MEMORANDUM

RE: LS Residence (Permit #1708-086), Mercer Island Corrections Notice 1, dated 1/17/18.

A507

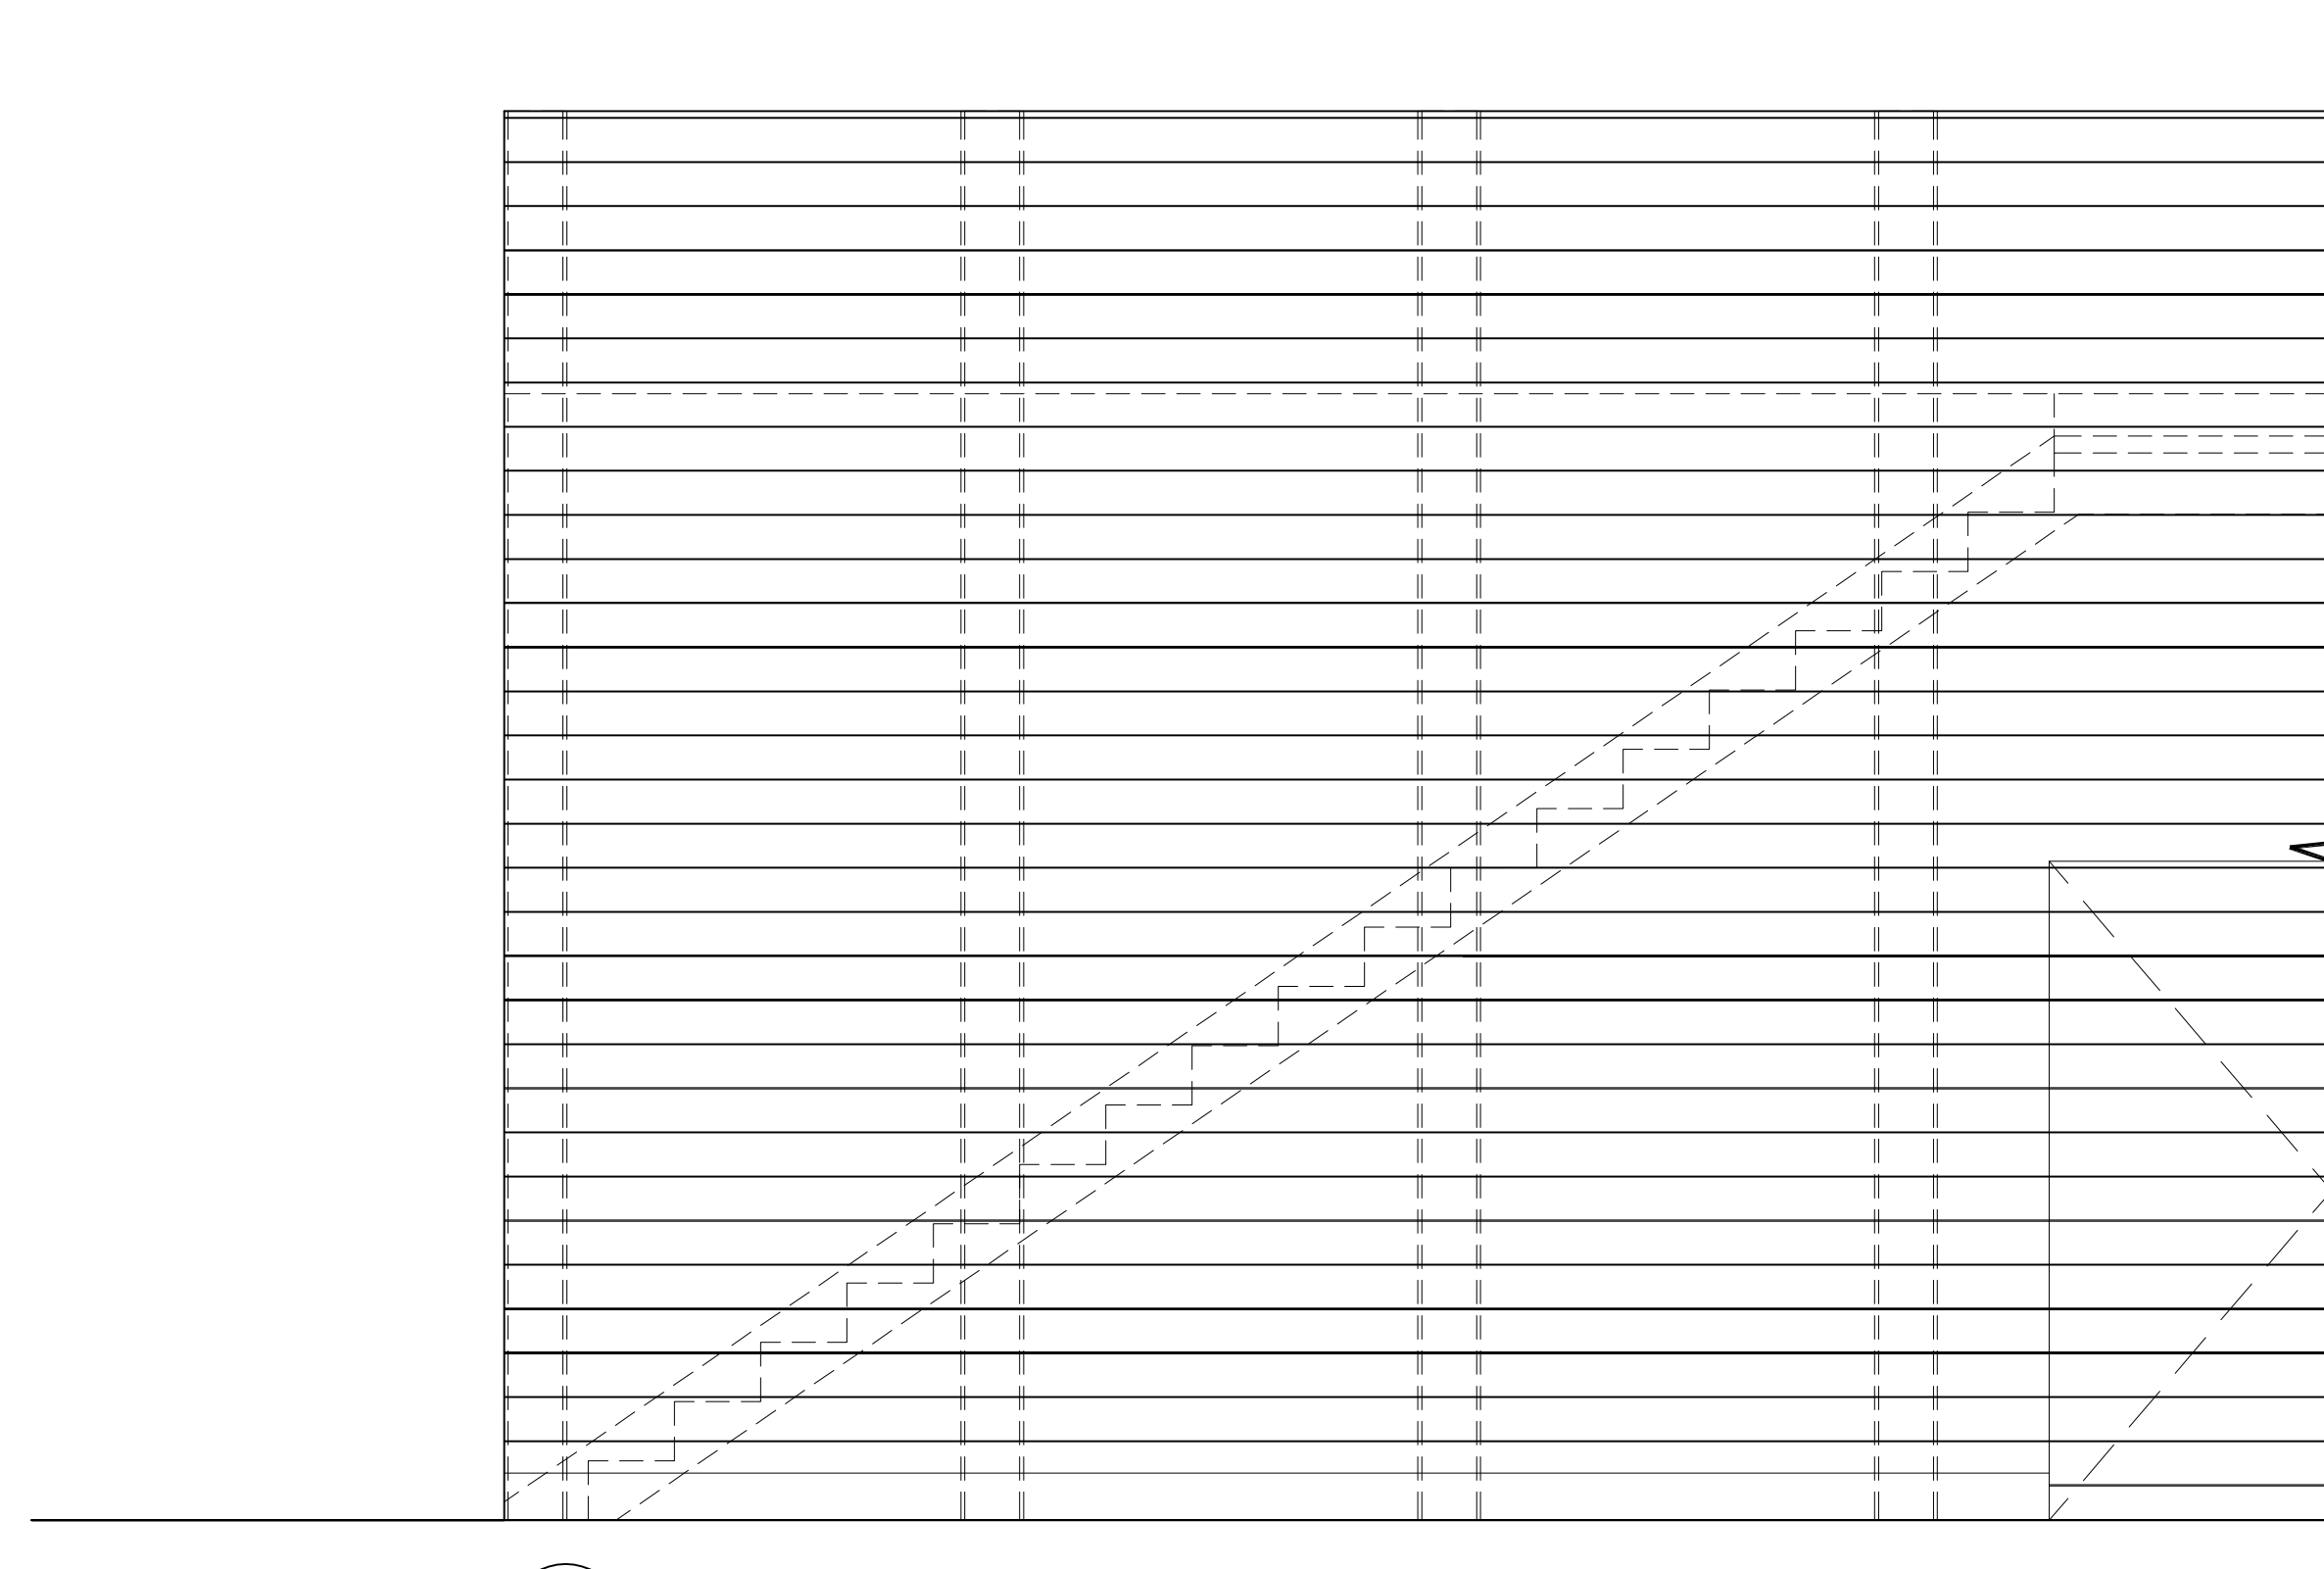
- 3) *Coordinate with arch to provide footings for exterior stair (see A507)*

Strip footing has been added to the plan sheet as well as a new detail (5/S3.0) to show footing and wall detailing at exterior stair.

ISSUE
 PERMIT **A508**

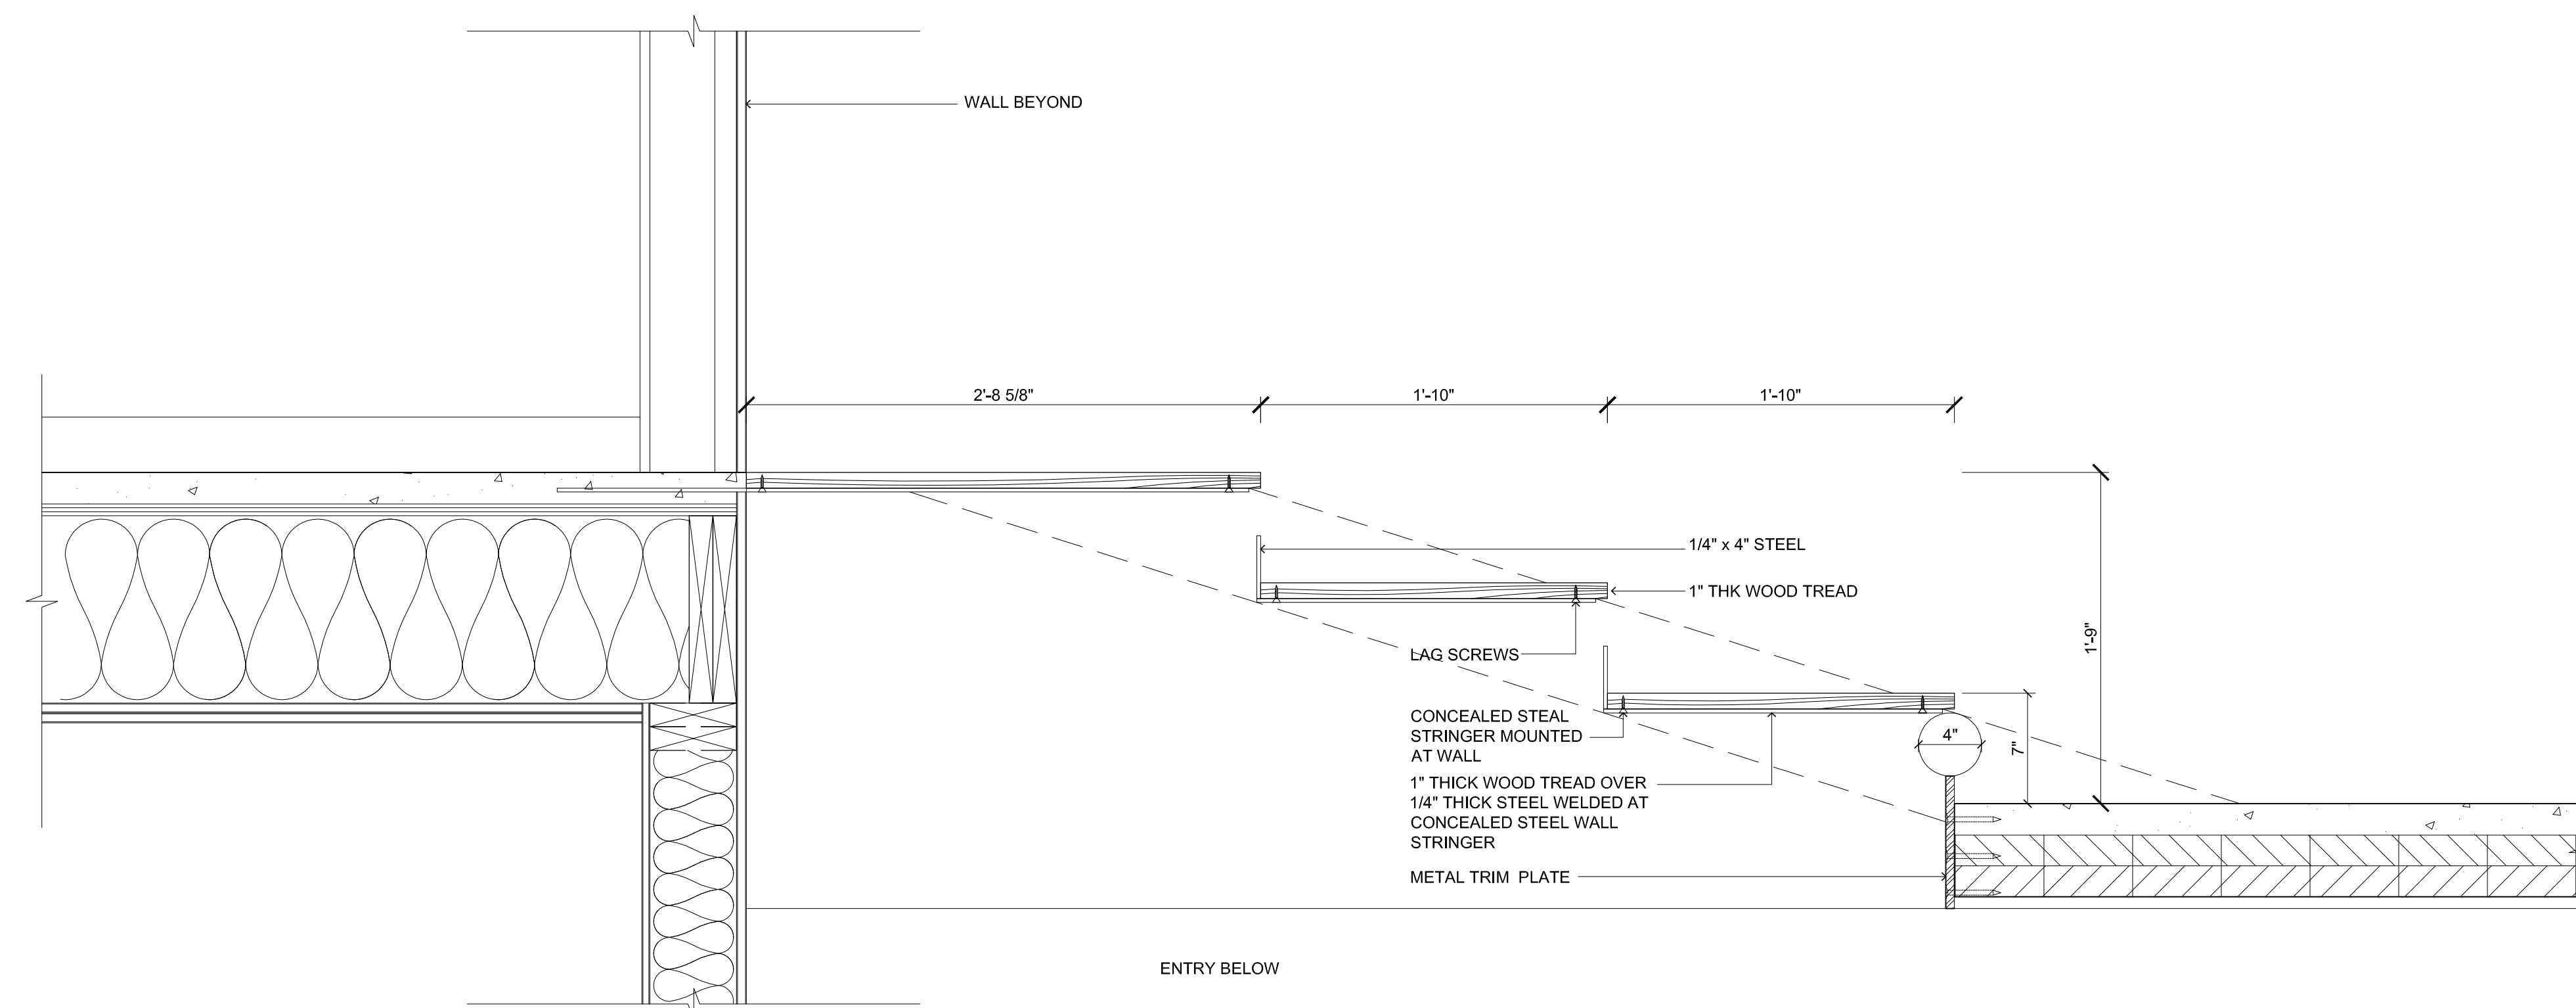
-
- S2.2** 1) *Coordinate with arch where the open stair 1/A508 is shown on upper floor plan A102. The change in elevation reflected in detail 4/S4.2 along Grid 2 appears to occur elsewhere in the arch set.*

Stair opening have been coordinated with the architectural set. Detail 4/S4.2 has been updated to more accurately match architectural sections.
